Our Case Number: ACP-322958-25

Re: Athlone link road phase 2. Proposed link road, joining the Crescent Junction (R915) to Southern Station Road Junction
Athlone, County Westmeath

Observation on a Strategic Infrastructure Development Application

Athlone link road phase 2. Proposed link road, joining the Crescent Junction (R915) to Southern Station Road Junction

Drawing file: Drawings / 120278-5001 PL1 Vegetation to be Removed.pdf

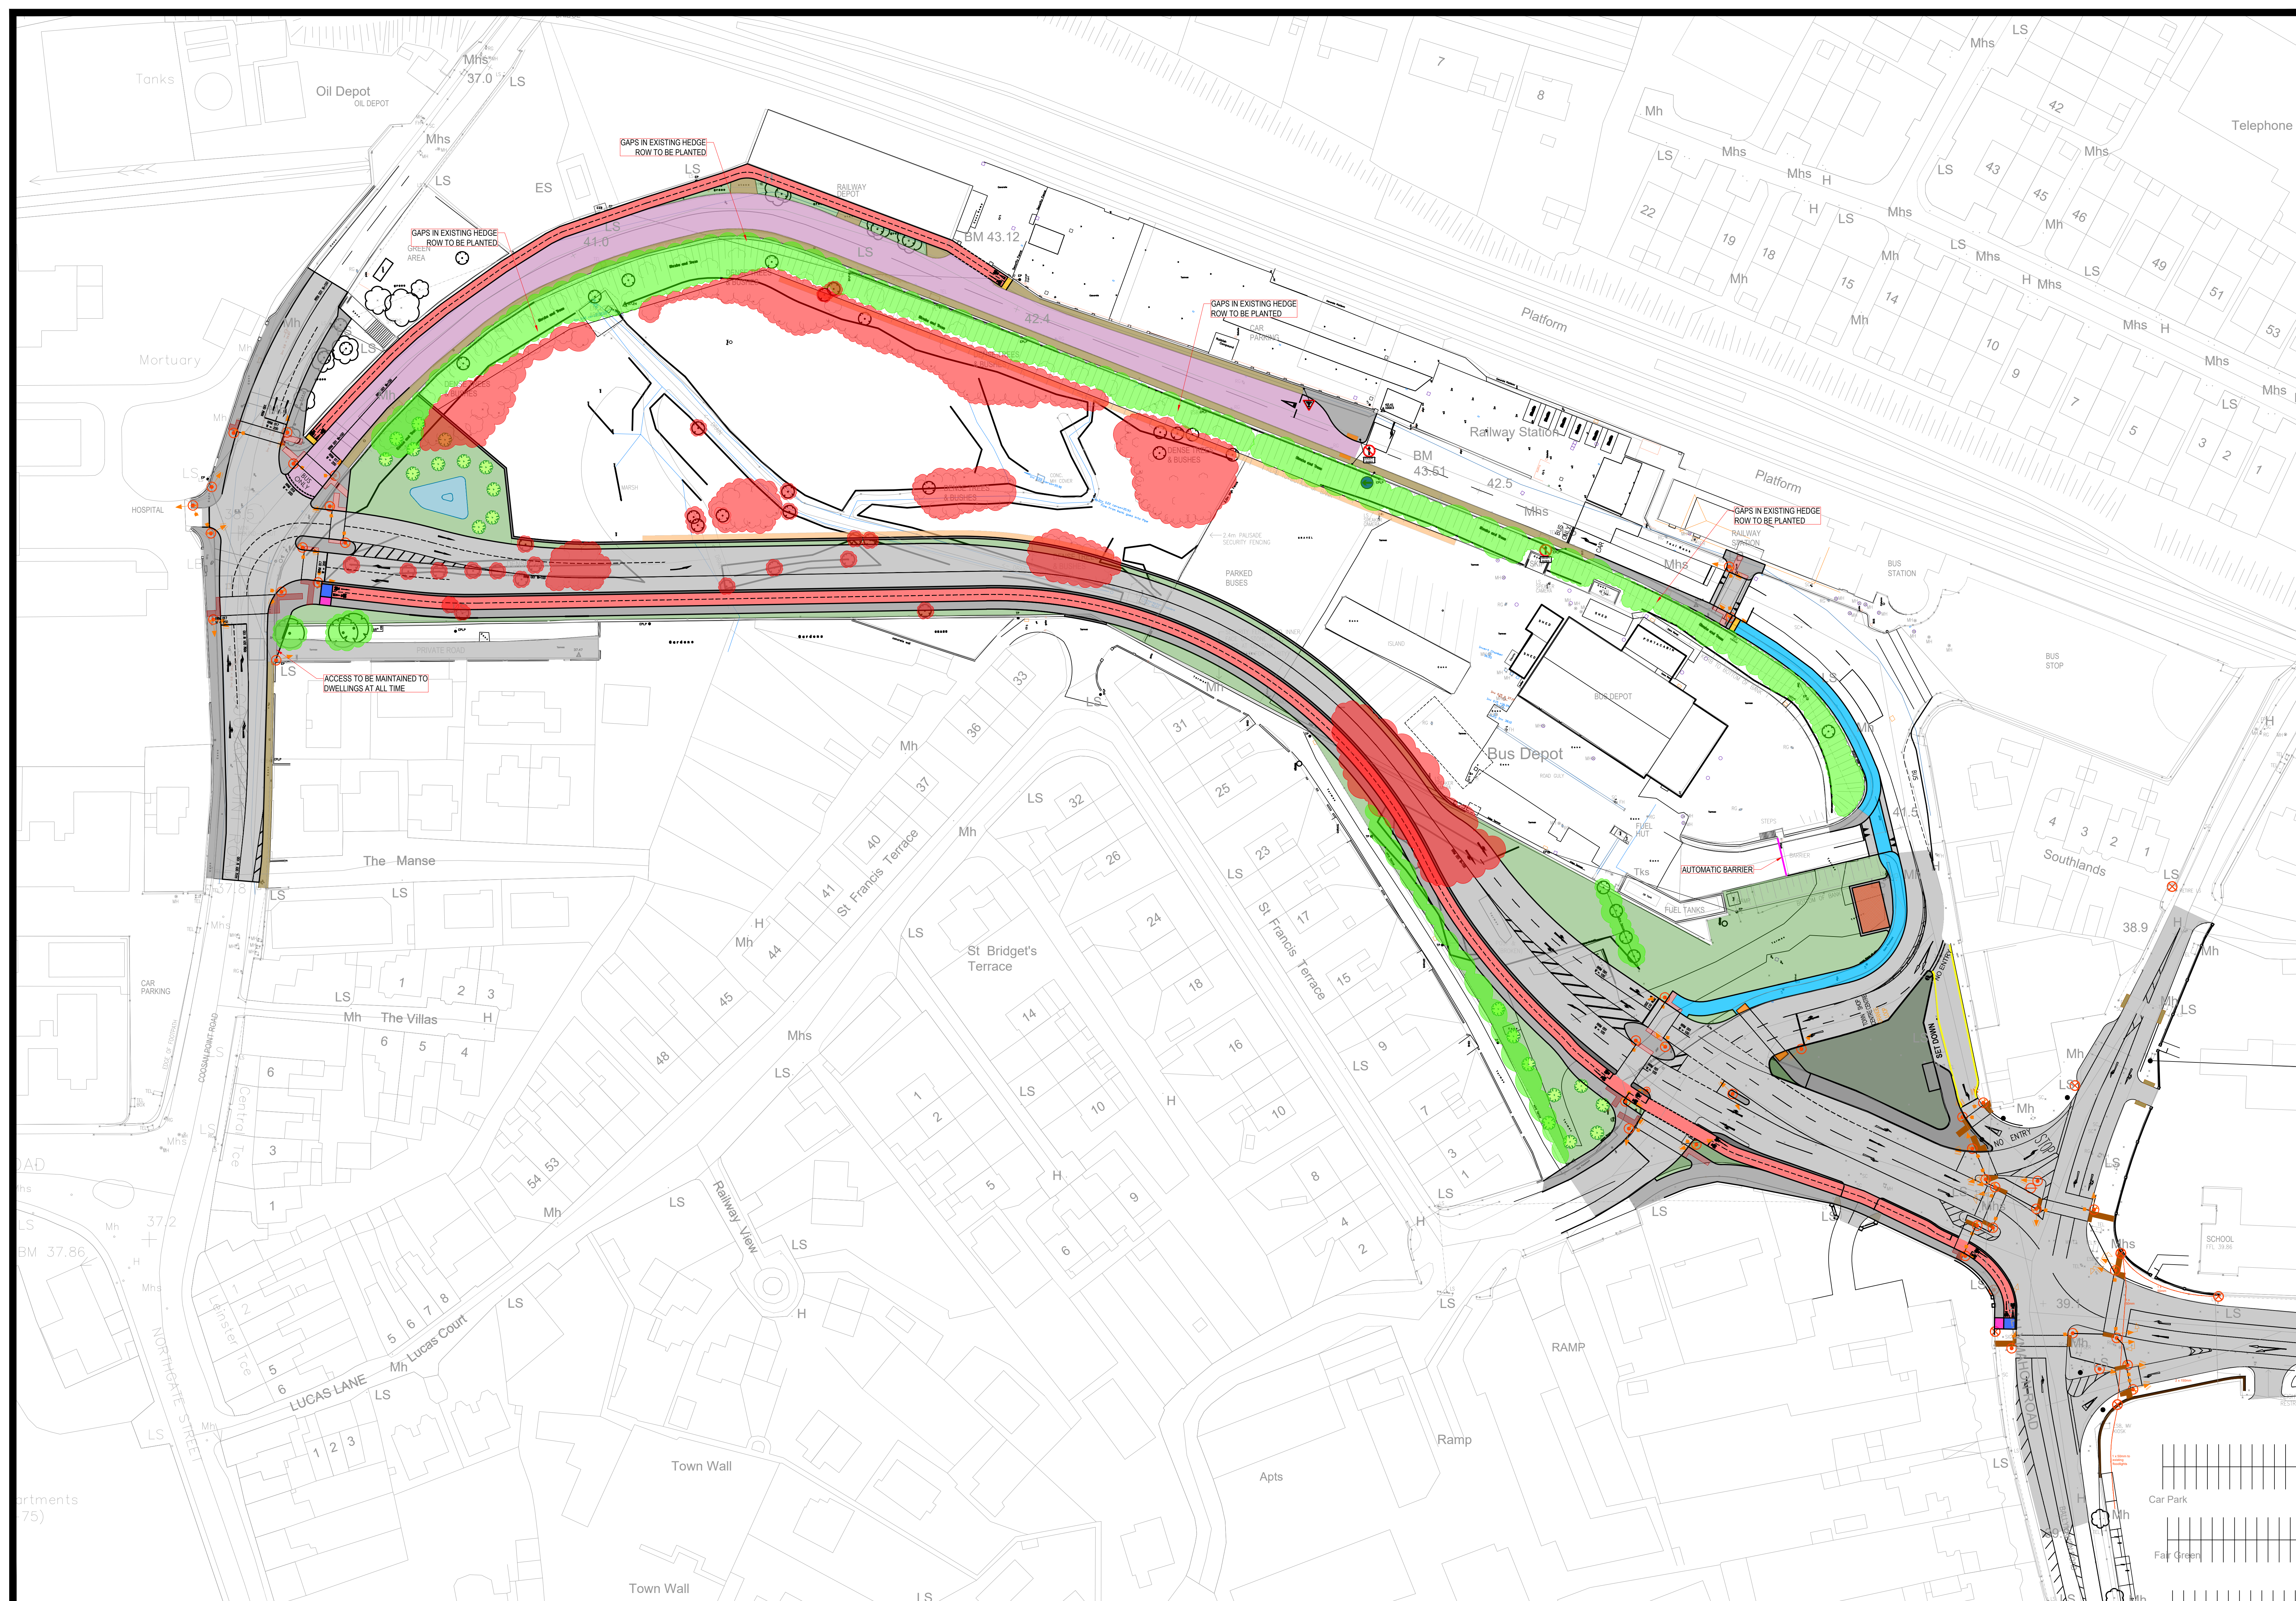
The proposal entails substantial removal of trees, wetlands, and meadows that are crucial for maintaining local biodiversity and mitigating air pollution. The drawing 1202785001_PL1_Vegetation_to_be_Removed is inaccurate and misleading. See below figure 4.2 from Page 20 of the Natura Impact Statement by Coisceim Consulting Ltd. illustrating the biodiversity and vegetation currently on the site.

The submitted drawings underestimate the extent of vegetation clearance, which will exacerbate poor air quality issues already documented by the Athlone Air Quality Monitor, with particulate matter levels exceeding WHO guidelines. The increase in bus depot capacity from 13 to 44 buses threatens elevated noise and air pollution near residential areas.
